Planning Application Technical Response

Site: Land at Toddington
Lane
Littlehampton
BN17 7PN

Reference: LU/246/24/PL

Lead Local Flood Authority
Northleigh
County Hall Chichester
West Sussex
PO19 1RH

PROJECT NO:	DRAWING NO:	REV:
20240453	251-A	T3

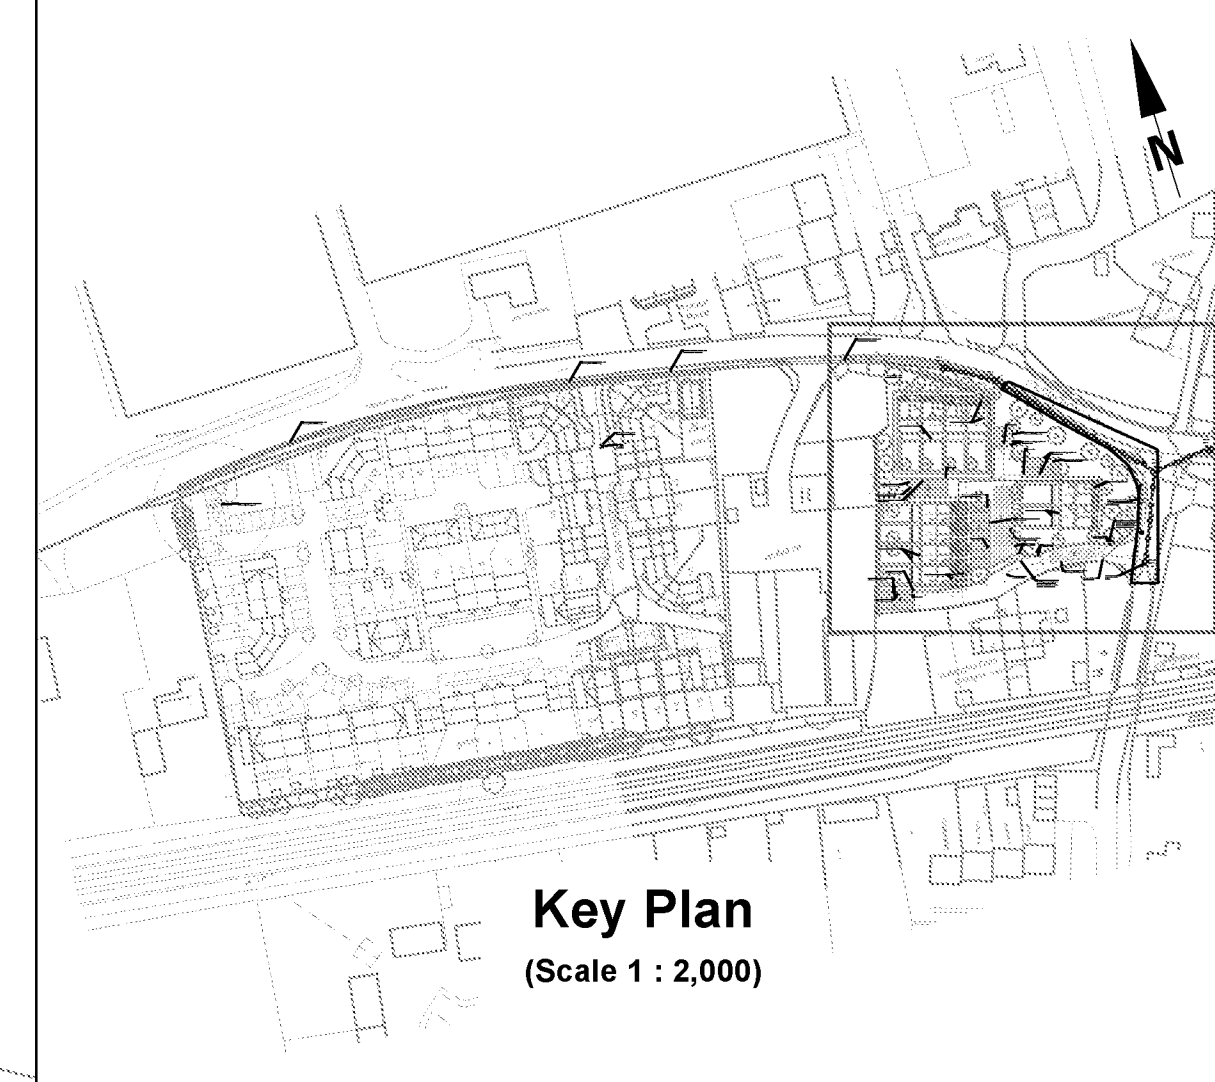
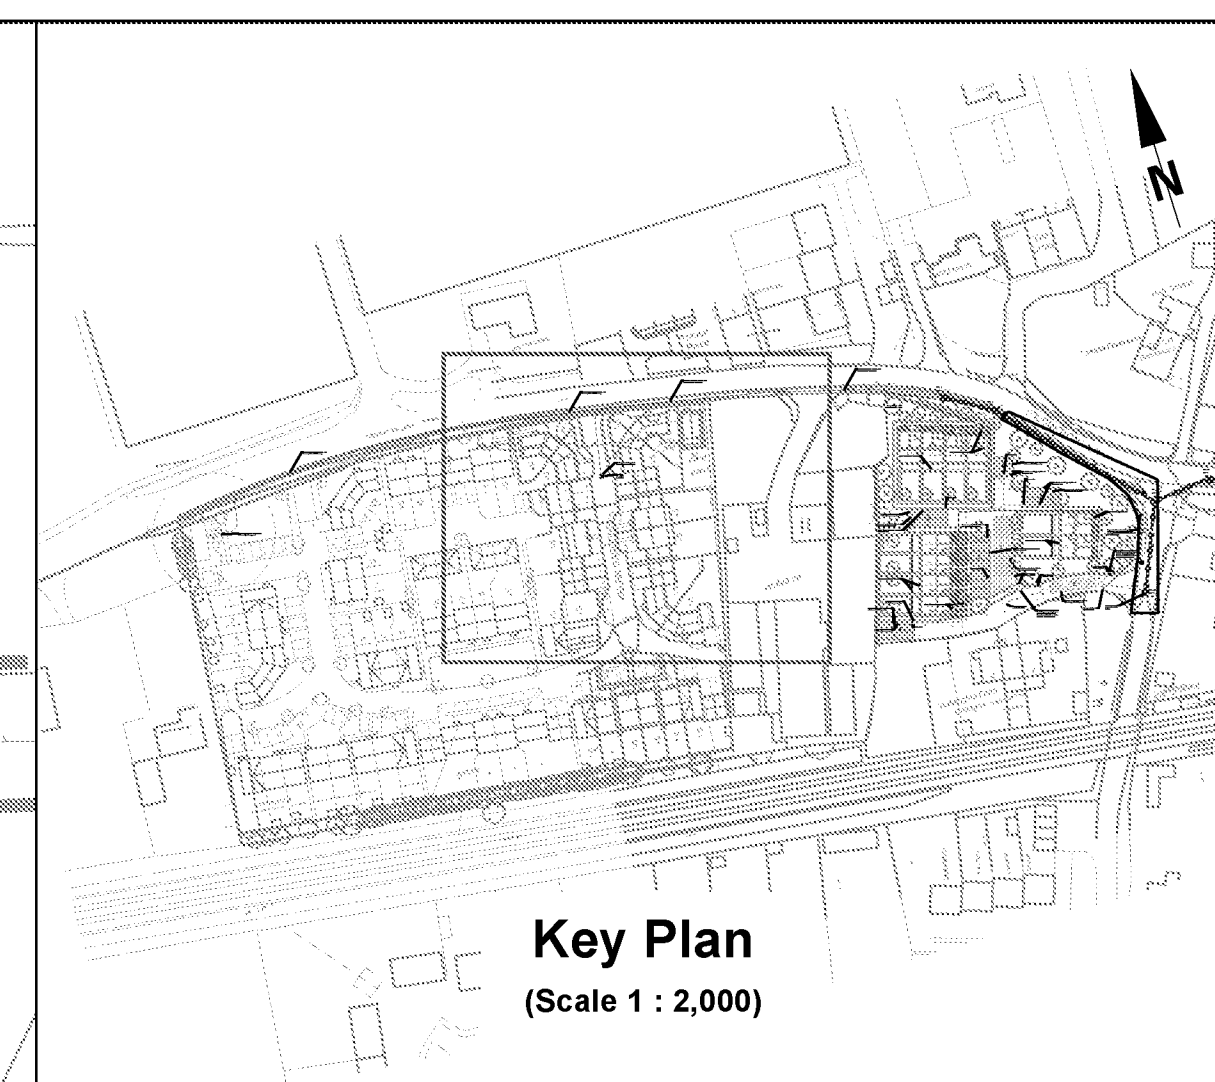
FULL APPLICATION	Related Policy or Standard	Applicant Action Required	LLFA Specific Comment
Location of SuDS		<p><input type="checkbox"/> Drawings need to show all the drainage features (storage and conveyance) with labels the same as those in supporting calculations</p> <p><input checked="" type="checkbox"/> Drawings need to show the final design (but not construction issue or preliminary issue).</p> <p><input type="checkbox"/> Cross sections and long sections of all the network and structures such as ponds, basins and swales</p>	<p>Objection: Please provide supplementary information for consideration. Are the planters part of the strategy?</p>
What is the impact of flood risk on the development?	<p>NPPF Paragraph 169</p> <p>SDNSTS S7, S8, S9, S10 and S11</p> <p>Policy SD1a, ECC SP1, WDM2, WDM3</p>	<p>Updated supporting calculations required to show;</p> <p><input checked="" type="checkbox"/> 50% AEP rainfall event does not surcharge in the drainage network</p> <p><input checked="" type="checkbox"/> 3.33% AEP rainfall event plus climate change does not flood outside the drainage network which is designed to hold water.</p> <p><input checked="" type="checkbox"/> 1% AEP rainfall event plus climate change does not leave the application boundary or flood any part of a building, utility plant susceptible to water (e.g. pumping station or substation) within the development boundary.</p> <p><input checked="" type="checkbox"/> the appropriate climate change allowance must be included</p> <p>Additional information is required showing;</p> <p><input type="checkbox"/> above ground flooding (extent and depth) at the 1% AEP rainfall event plus climate change must be shown on a drawing with proposed external ground levels and proposed finished floor levels of buildings</p> <p><input type="checkbox"/> above ground flooding (extent and depth) at the 1% AEP rainfall event plus climate change should be designed to be held in the least vulnerable areas of the site e.g. open space</p> <p><input checked="" type="checkbox"/> Flood resistance and resilience must be shown to be included in the design. A minimum of 300mm must be provided between the design flood event and the finished floor level</p> <p><input checked="" type="checkbox"/> A minimum of 150mm above external ground levels and shown that they are sloping away from vulnerable areas such as doorways</p> <p><input checked="" type="checkbox"/> Exceedance of the design 1% AEP rainfall event plus climate change (or failure of the drainage network) must be shown on a</p>	<p>Objection: Please provide calculations</p>

FULL APPLICATION	Related Policy or Standard	Applicant Action Required	LLFA Specific Comment
		<p>drawing, minimising impacts to people and property. This drawing will include proposed external ground levels, finished floor levels and any designed slopes on impermeable surfaces such as highways or car parks</p> <p><input checked="" type="checkbox"/> ½ drain down times need to be submitted and show that they are within 24 hours (or within 48 hours for features that are lined e.g. lined tanks or lined basins)</p> <p><input type="checkbox"/> Any drainage network showing storage features with ½ drain down time greater than the 24 hours (or 48 hours for lined structures) must be redesigned to show how it can meet this standard or increased in size to accommodate an subsequent storm event of 3.33% plus climate change allowance.</p> <p><input checked="" type="checkbox"/> The drainage calculations must be shown to include a surcharged outfall to a watercourse or sewer. This surcharge level must be the 1% AEP flood event of the receiving watercourse if known or bank full if not already hydraulically modelled.</p>	<p>Objection: Please provide information.</p> <p>Objection: Please provide information.</p> <p>Objection: Please provide information.</p> <p>Objection: Please provide information.</p>
